Re Application to modify development consent - Cargill Australia Limited

I refer to the electronic mail received from the Department of Planning (DoP) on 28 April 2010 requesting an assessment by the Department of Environment, Climate Change and Water (DECCW) of additional information provided by Cargill Australia Limited in relation to an application to modify development consent DA No 220-07-2002-I as a result of a proposed upgrade to the effluent treatment system at their Bomen plant.

Effluent Irrigation - Addendum to Statement of Environmental Effects - Sections 1.3 and 3.3

Odour - Addendum to SEE section 4 and Appendix D

## Cargill Wagga\_All Sources\_2010

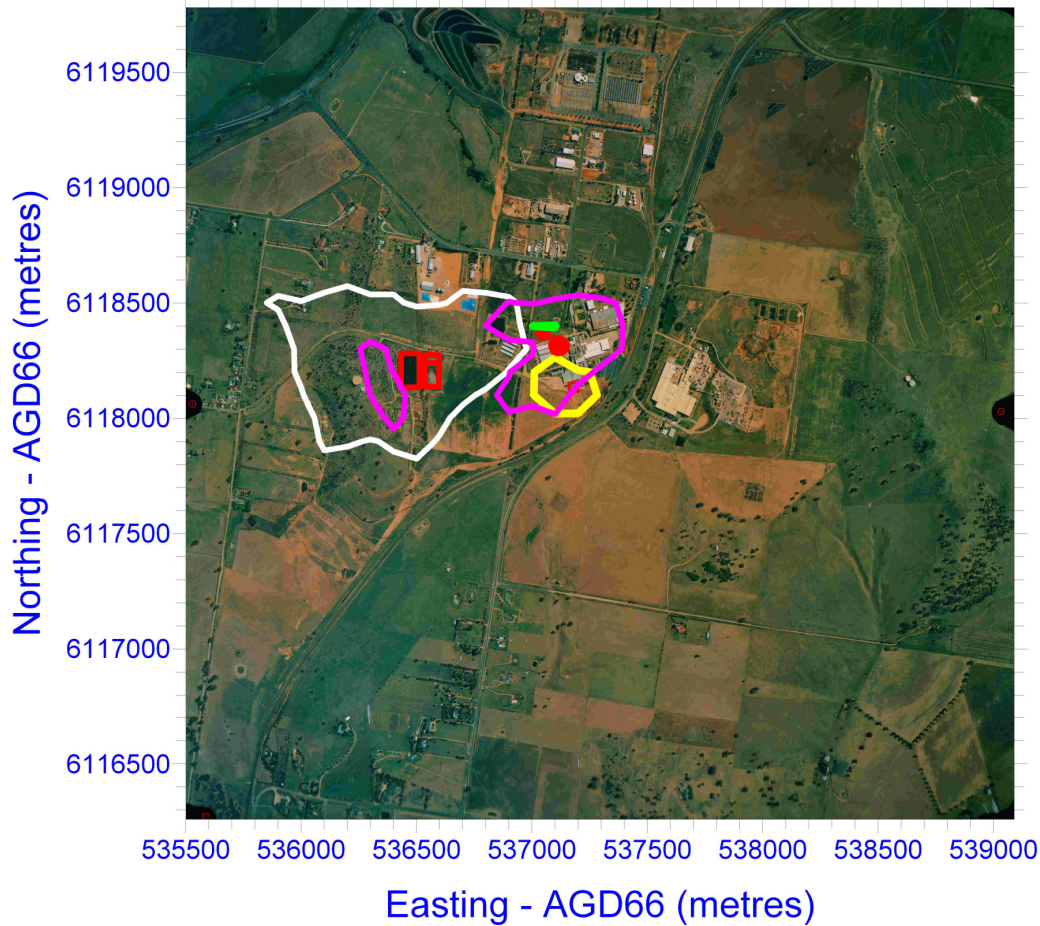
We have undertaken an assessment of the odour modelling outlined in section 4 of the Addendum to the Statement of Environmental Effects (SEE) as well as Appendix D provided in support of the SEE. In summary, we consider the assessment provided in Appendix D is not suitable to determine the magnitude of the reduction in odour impacts for the following reasons.

- Irrigation can be a significant source of odour if not carefully managed. The odour assessment provided states that odour from effluent irrigation has not been included in the assessment.
- The combustion of the anaerobic gases has the potential to produce significant odours if not managed appropriately. The odour assessment states that odour from flaring of the pond gases has not been included in the assessment as it was deemed to have negligible odour impacts.
- The modelling shows contours for each of the individual sources of odour, specifically biofilter, rendering plant, waste water treatment system and cattle lairage. The reasoning for plotting each of the odour sources separately was that they had noticeably different odour character. This approach is not supported. The cumulative odour contours should be provided for a more accurate prediction of the reduction in odour.

Whilst we expect that the project, if implemented and managed appropriately, should lead to a considerable reduction in odour generated from the site, the magnitude of this reduction cannot be assessed from the information provided. Given the proposed timeframe for the development, a comprehensive odour assessment may unduly delay the project. Additionally, it is unlikely that odour modelling prior to the proposed modification will provide a reliable assessment in terms of the net improvement. DECCW have a requirement in the Environment Protection Licence for a comprehensive odour survey and assessment following the implementation of the proposed works to determine any residual odour impacts and to demonstrate compliance. If the proposed works do not adequately address the odour impacts from the facility, then additional control measures will be required.

In the event that offensive odours are generated from the flaring of the anaerobic pond gases then additional emission controls will be required.

In the event that offensive odours are generated from the irrigation of effluent then irrigation must cease and alternative disposal methods must be implemented.
